Your Ref: OWPC22365
Our Ref: AW/82/19/HH 18-03-2019
Please ask for:
Stuart Corbey

Single storey side & rear extension.
17 Downing Close Aldwick

Thank you for your internet representation made on 25th April 2019 which has been recorded as '**an objection**' with the comments as follows:

PROPOSED SINGLE STOREY EXTENSION AT 17, DOWNING CLOSE, WEST MEADS
FOR MR. & MRS. S. PAGE.

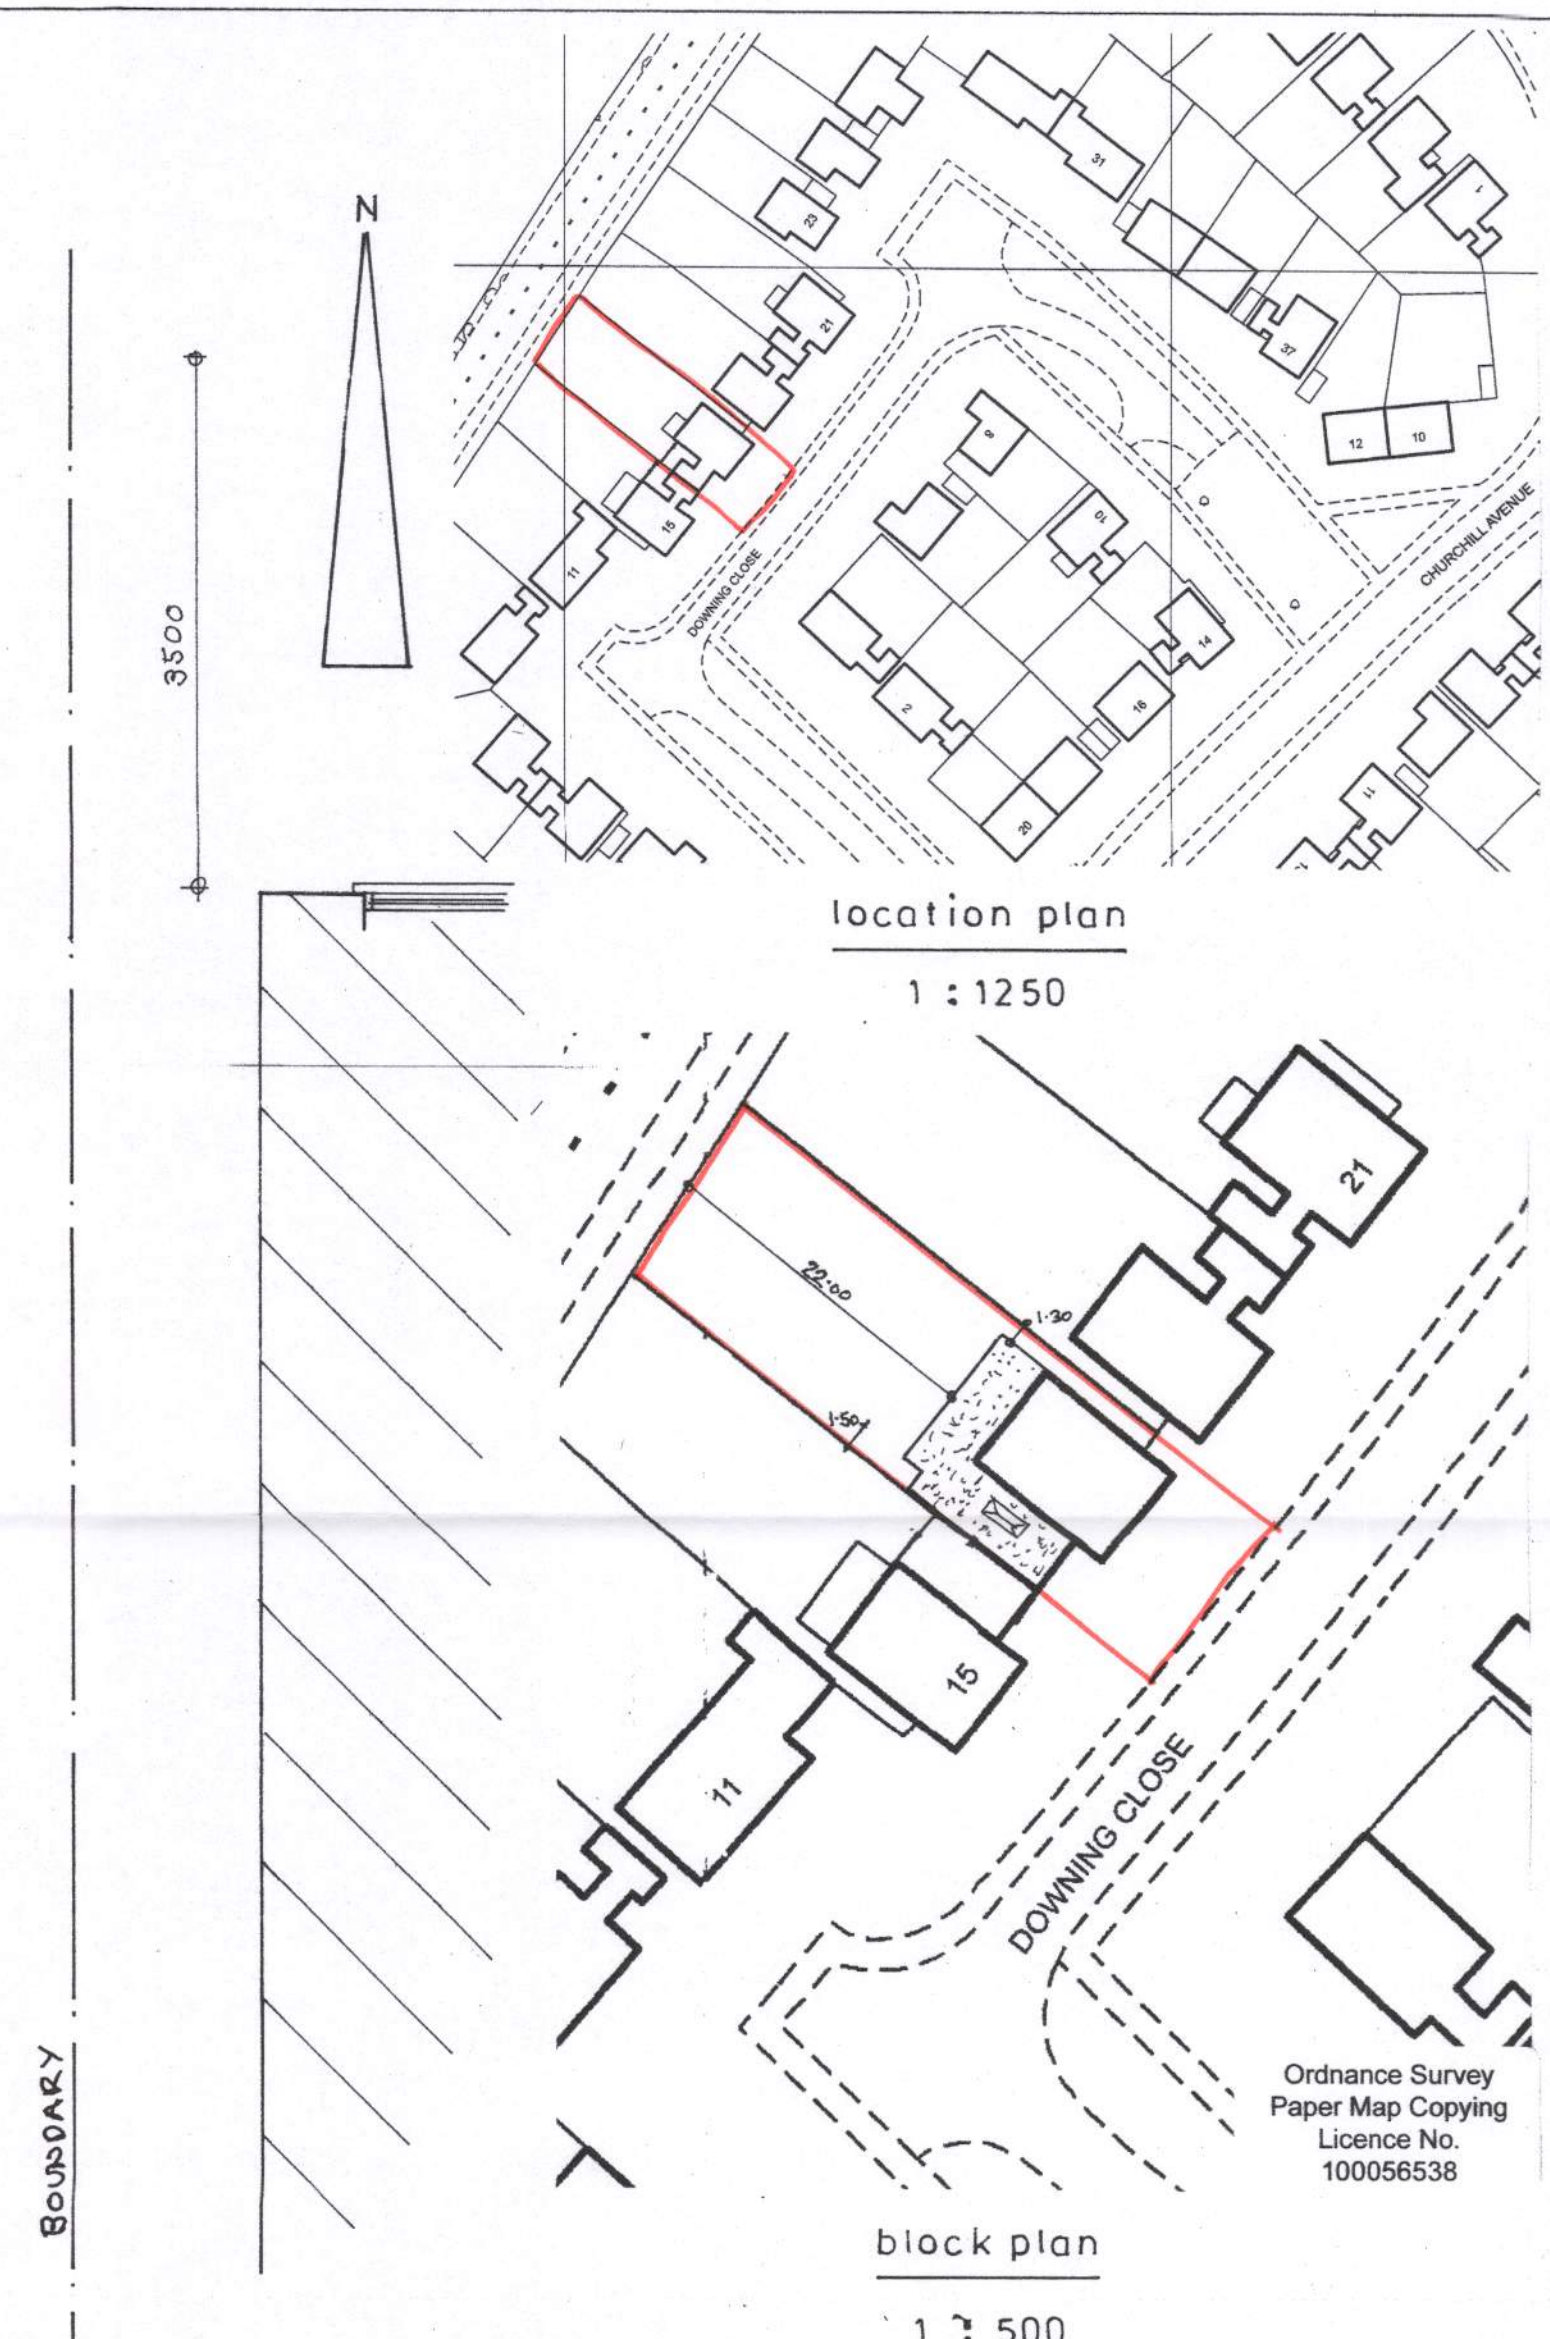
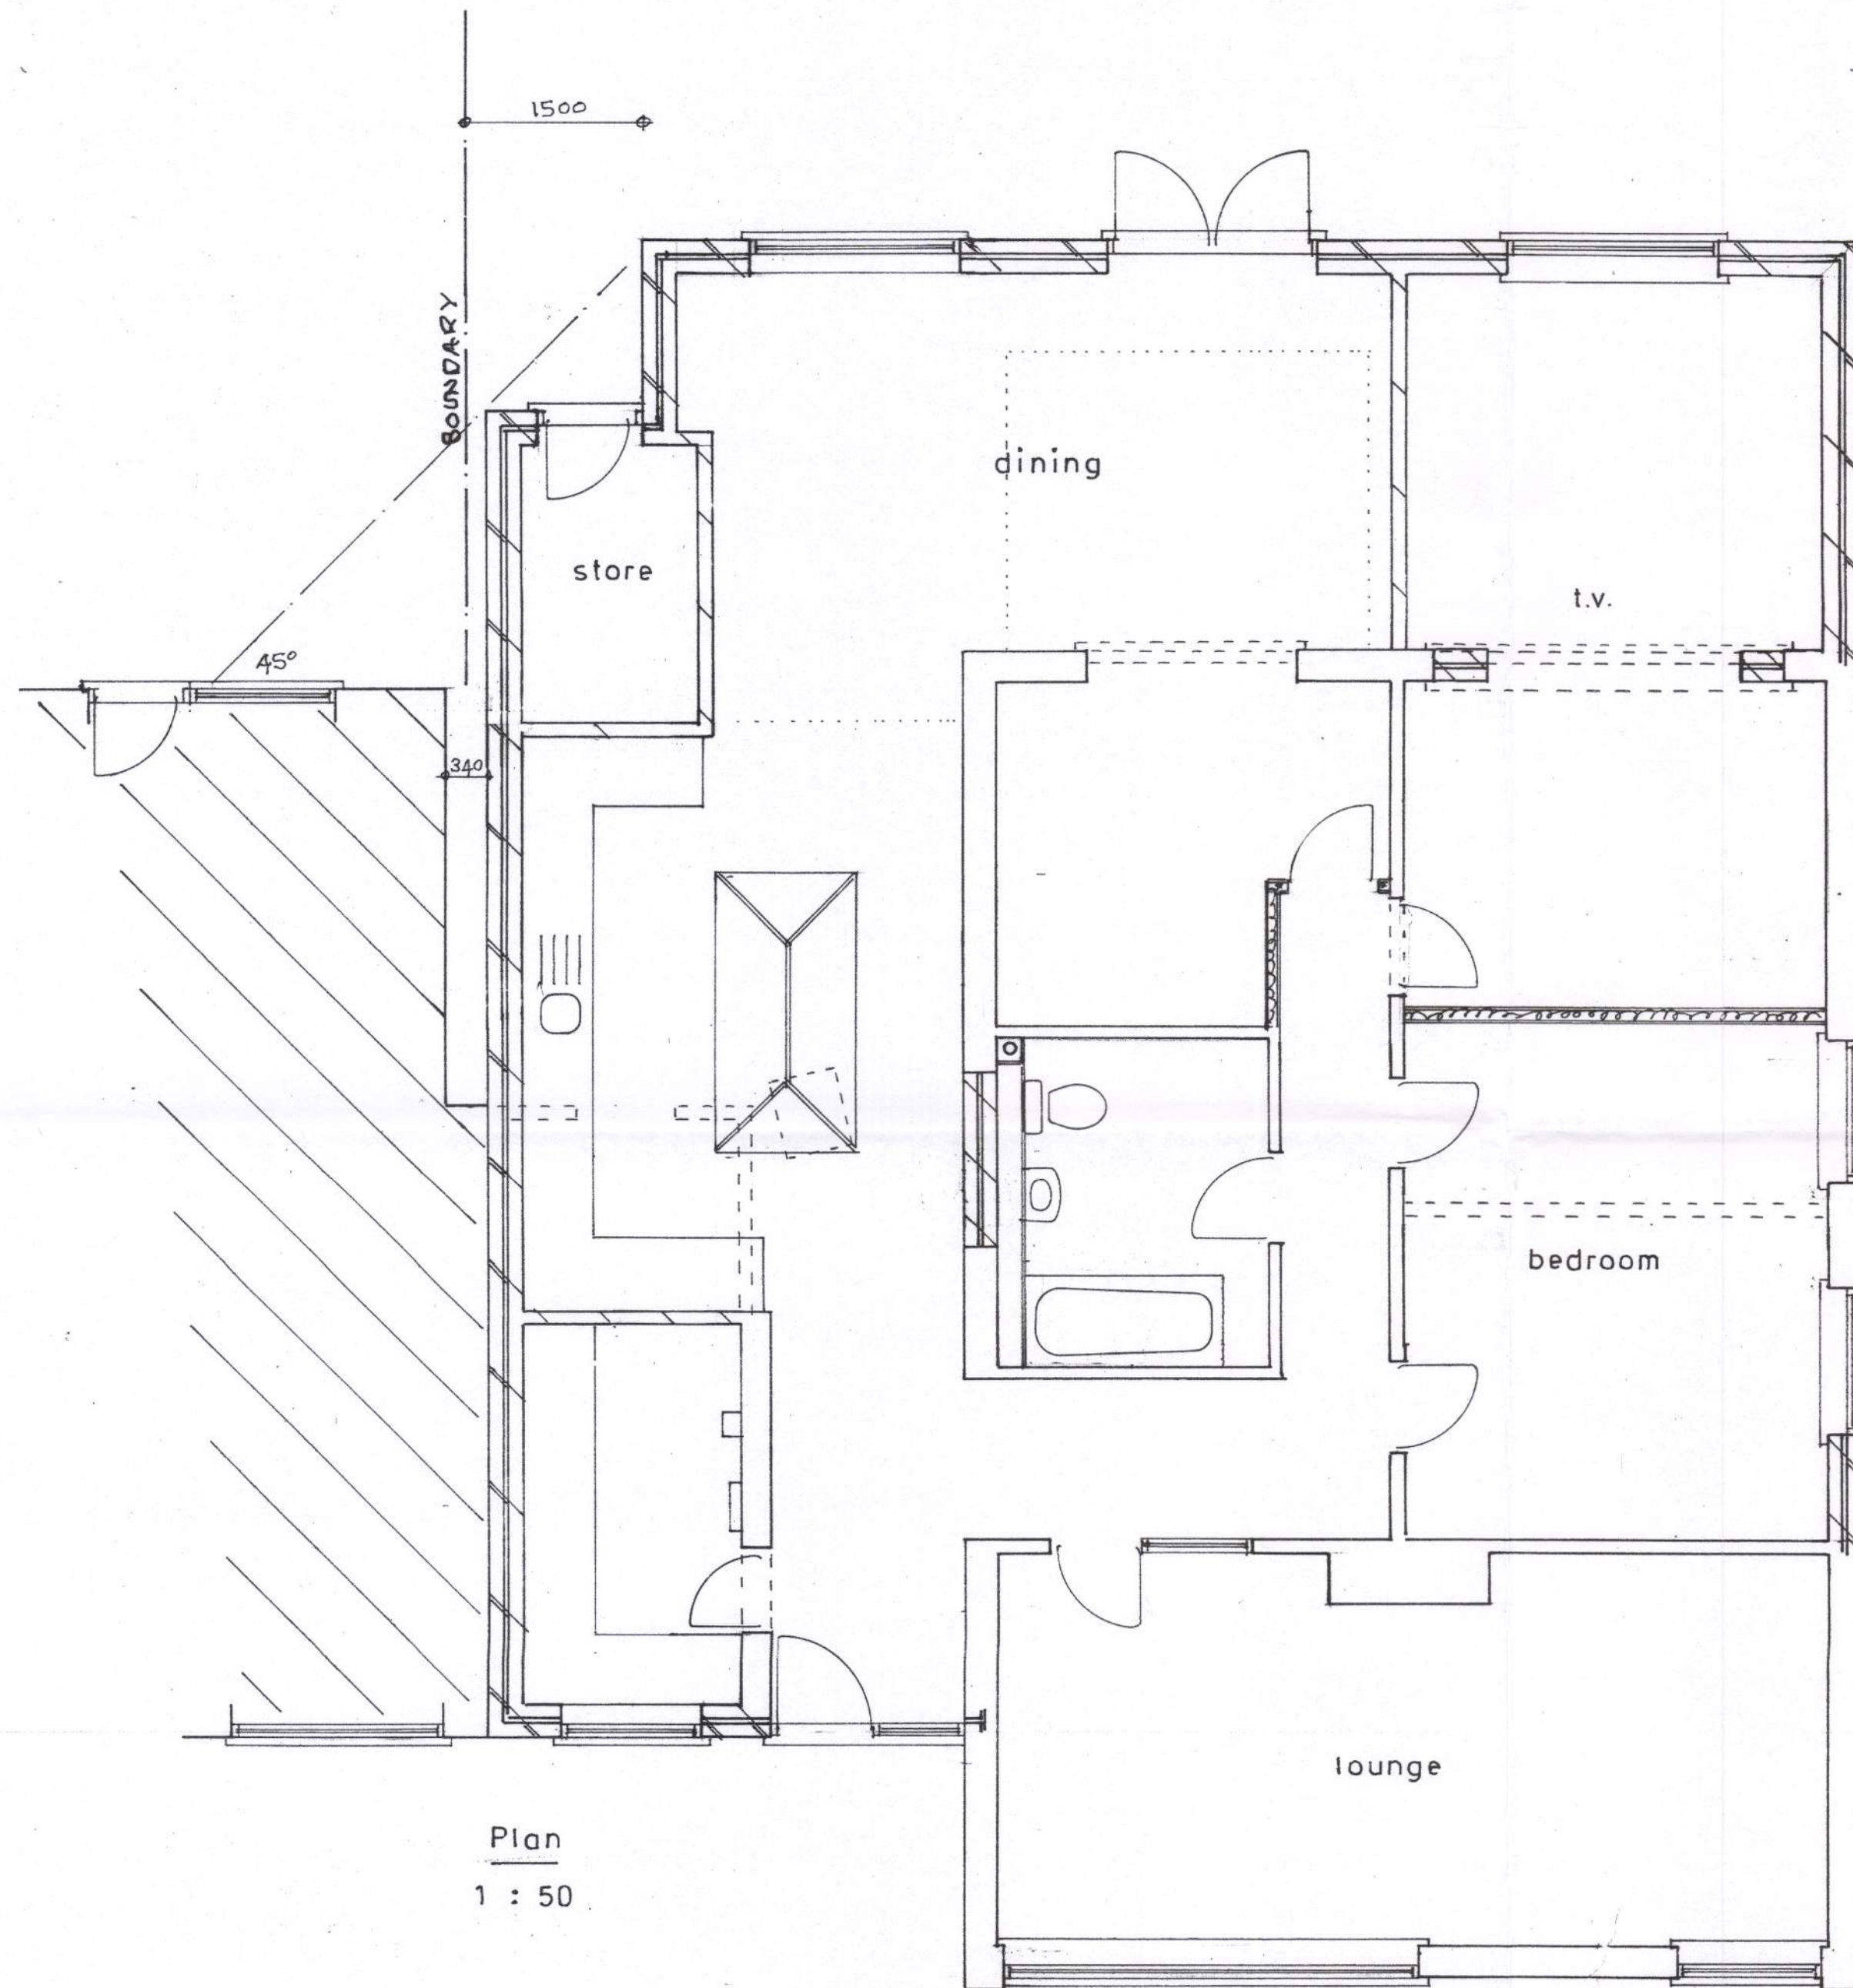
On Sheet 1 of 3, Proposed Block, Location, Layout plan

The proposed extension is now being taken out beyond the level of the rear of our property by quite a distance. This will impact on us markedly

Also on this document a 45 degree angle is drawn from the corners of the proposed extension to the window on the adjoining property (Our property)

Having looked in detail at the scale plans, we would like to point out that the drawings are inaccurate, and do not show the detail of the rear of our property, 15 Downing Close, accurately, and therefore the 45 degree rule has not been applied correctly, and the proposed extension crosses the correct line of the 45 degree rule in reality.

Therefore, we would appreciate it if the plans can be revised to take proper account of our 'right to light'.
